**Your  
Reference** SSD-35609161

**Our  
Reference** NCA/6/2022

30 August 2022

**City of Parramatta Council submission to State Significant Development Application for a mixed-use building, including 'Build to Rent' units at 12 Hassall Street, Parramatta**

1 NORTH ELEVATION
1 : 500

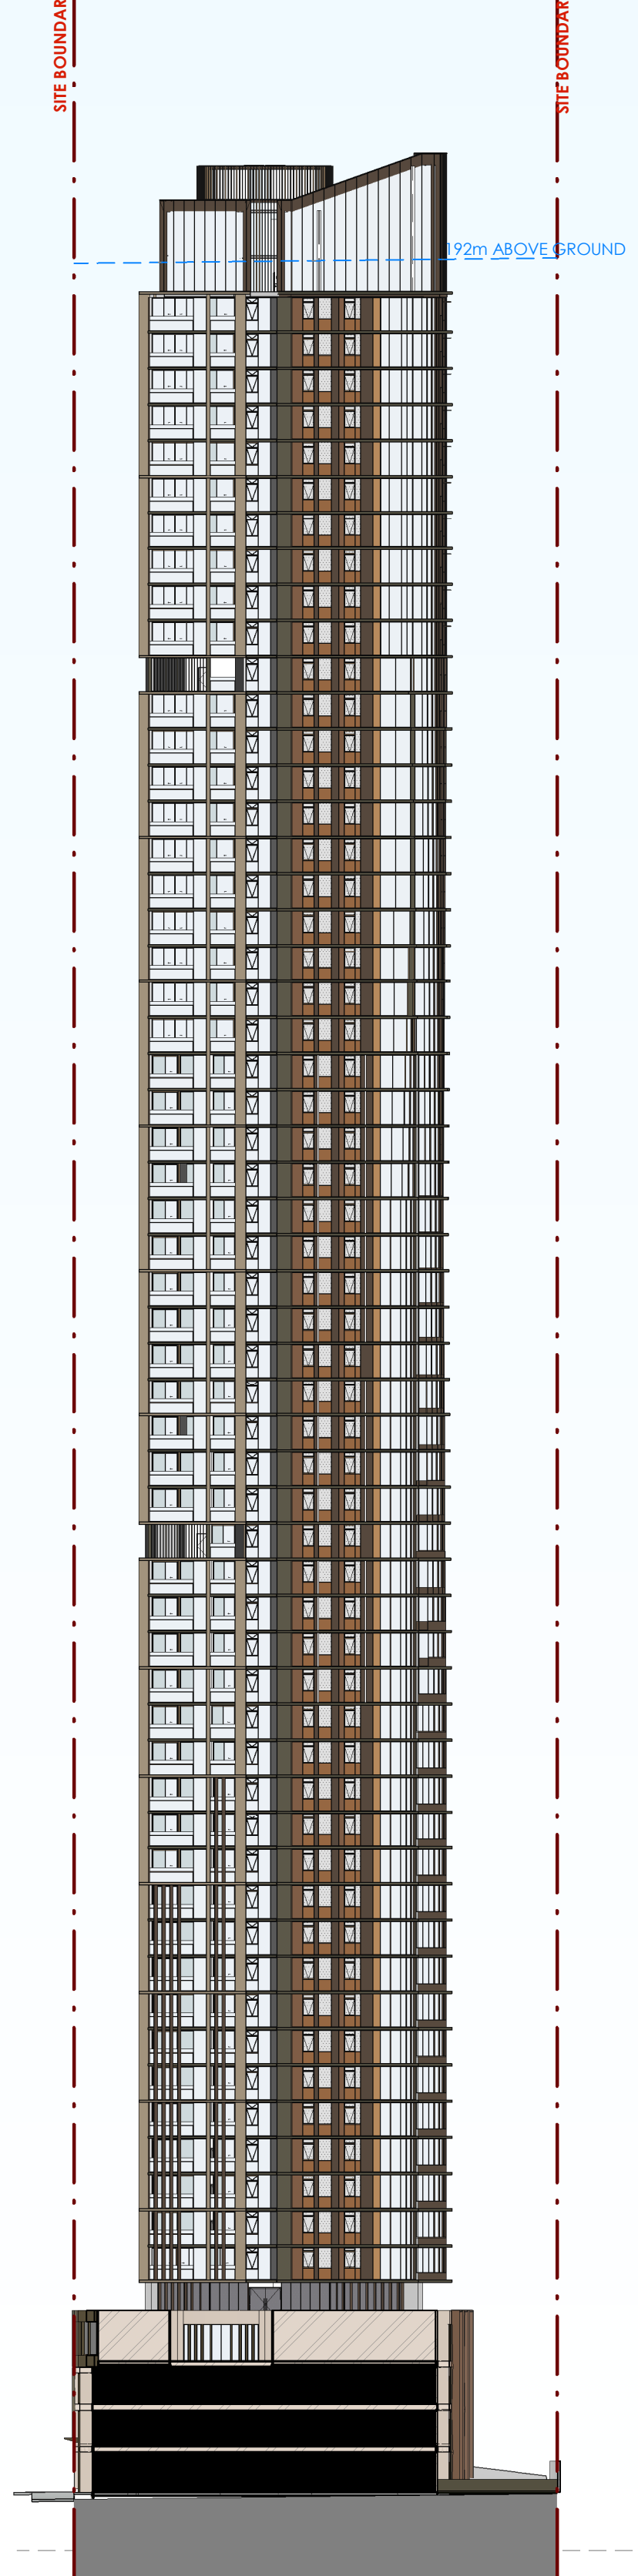
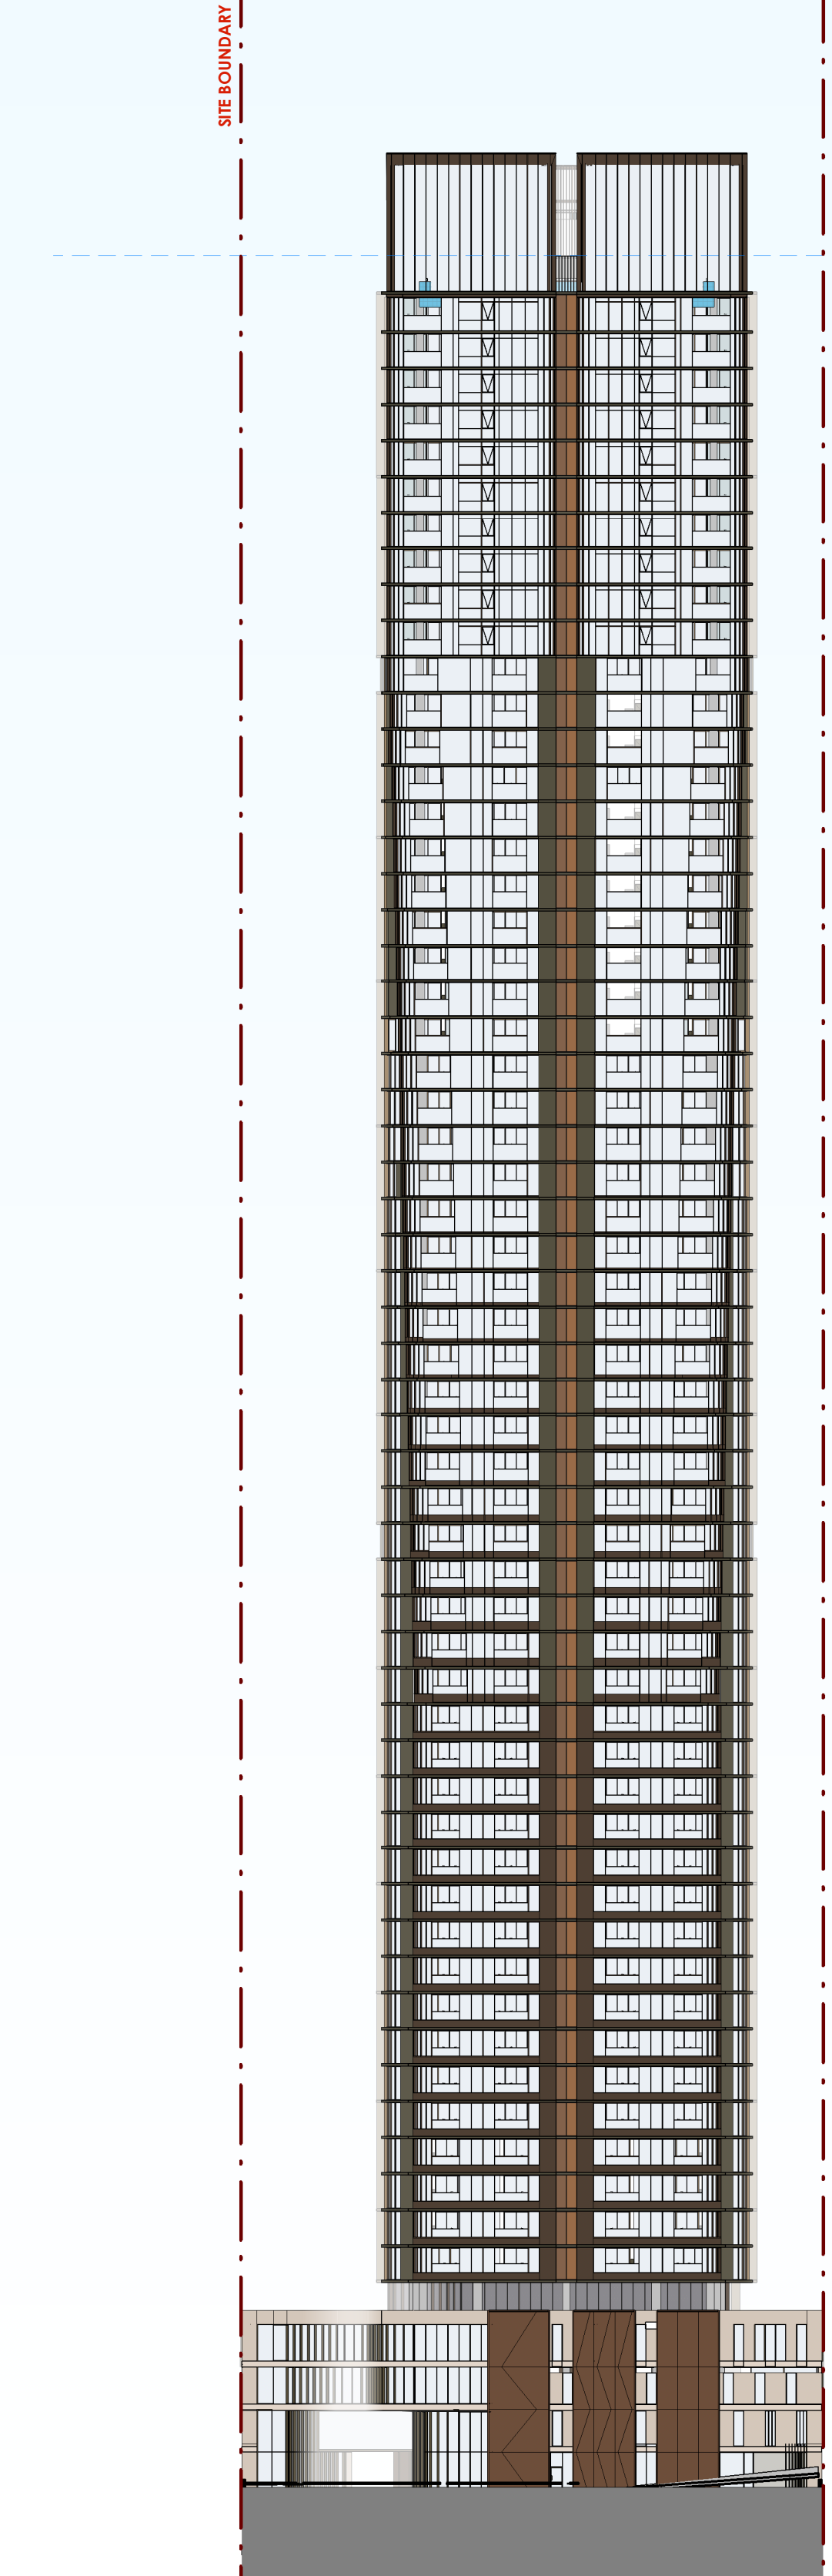
There is insufficient information contained in the Architectural Plans and Design Report to satisfy that the proposal meets the requirements of Clause 5.6 of PLEP 2011 of an architectural roof feature. More detail should be submitted in relation to the enclosed area located on the roof top. If the area is enclosed and constitutes a breach of the maximum height (or FSR), then the application must be accompanied by a Clause 4.6 Variation request.
